Rezoning Petition Review – Charlotte Tree Ordinance

Subject: City of Charlotte – Urban Forestry Rezoning Petition Review Summary

Review Date: July 29, 2021

Rezoning Petition # OR Pre-submittal meeting: 2021-080

PROJECT NO. MRE-13040  
 FILENAME: MRE13040-S1  
 DESIGNED BY: BGP  
 DRAWN BY: BGP  
 SCALE: 1" = 30'  
 DATE: 12-15-2017  
 SHEET NO. **RZ-2**

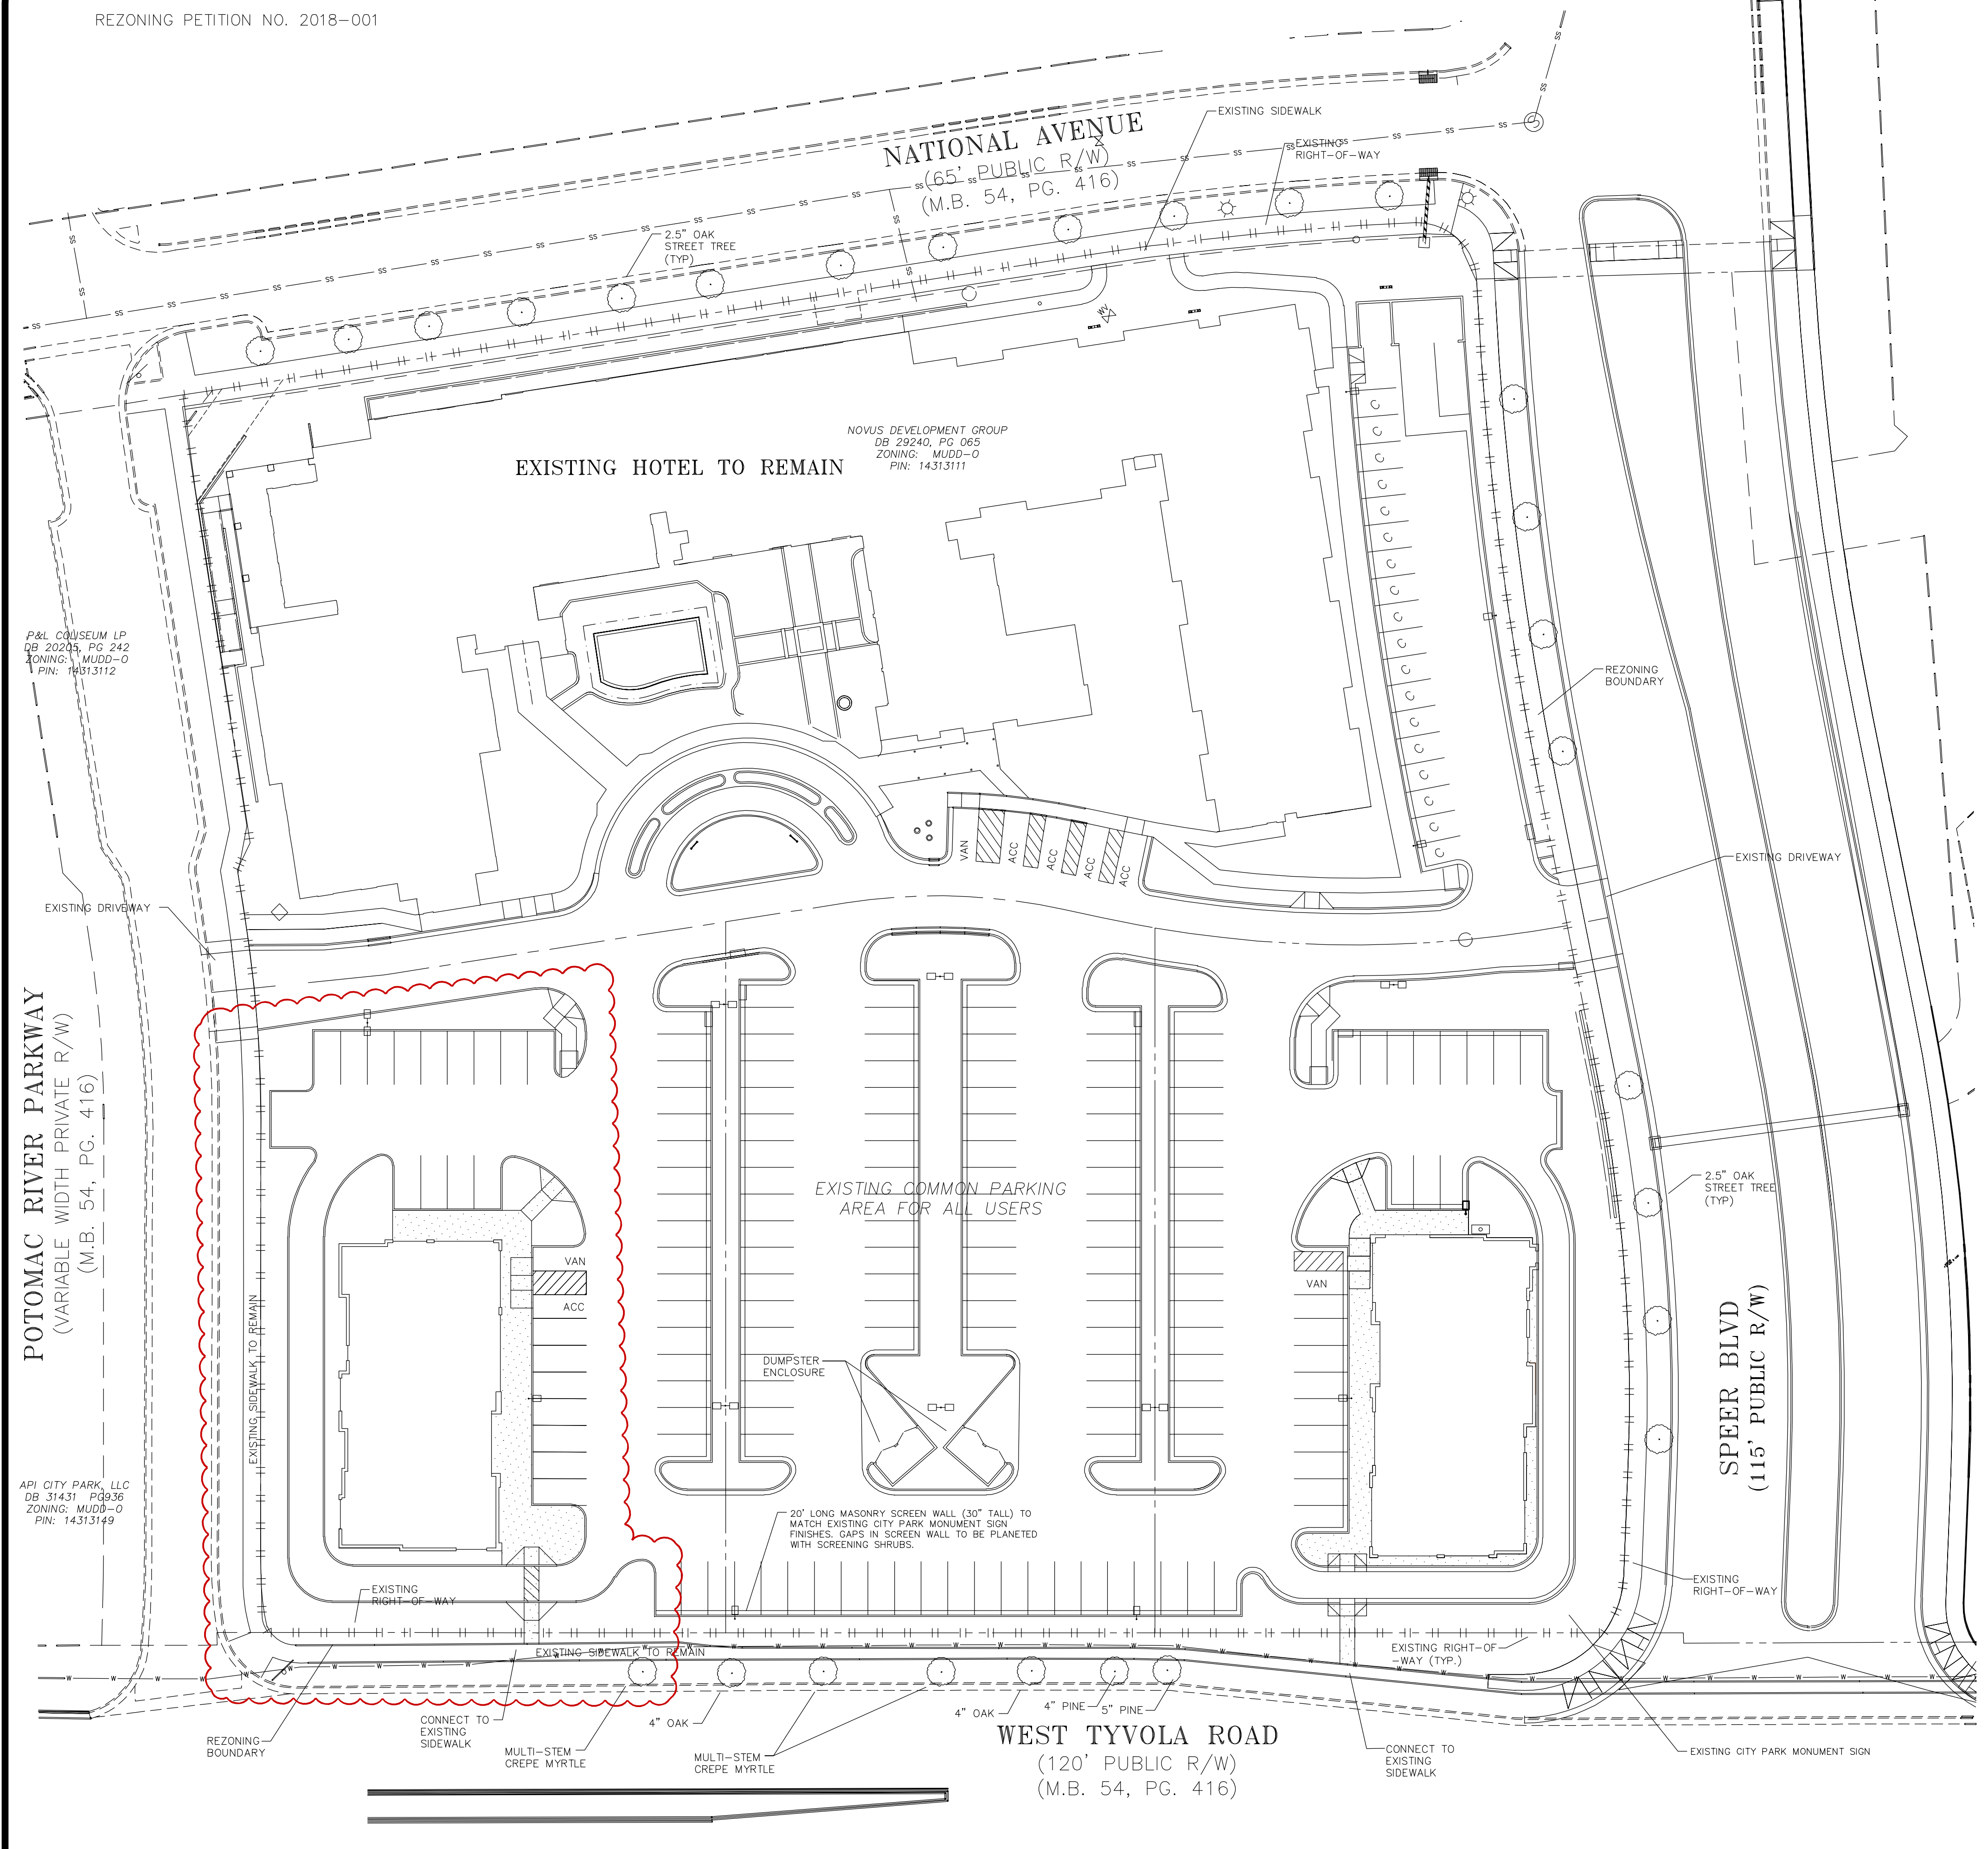
- A tree survey shall be submitted identifying all trees of eight-inch (8) dbh or greater and all planted trees of (2) two-inch caliper or greater and six feet in height that grow partially or wholly within public street right-of-way.

- All existing City street trees in public street right-of-way (City or State-maintained) are required to be preserved per the Charlotte Tree Ordinance and the following Tree Ordinance Guidelines: 1) City Trees & Protected Vegetation; 2) City Tree Mitigation Policy.

- Define potential on-site tree save areas and/or other option that will be utilized to meet Charlotte Tree Ordinance's commercial tree save requirement.
 - o Site qualifies for urban flexibility and amenitized tree area.

- Perimeter Trees: Street trees are required to be planted along all public roads per the Charlotte Tree Ordinance
 - o Small-mature tree species are required in locations where overhead distribution lines may impact natural tree growth.
- Internal Trees: Internal trees may be required to be planted in all surface parking lots and to mitigate impacts from impervious surfaces on-site.

- Add note: the site shall comply with the Charlotte Tree Ordinance.
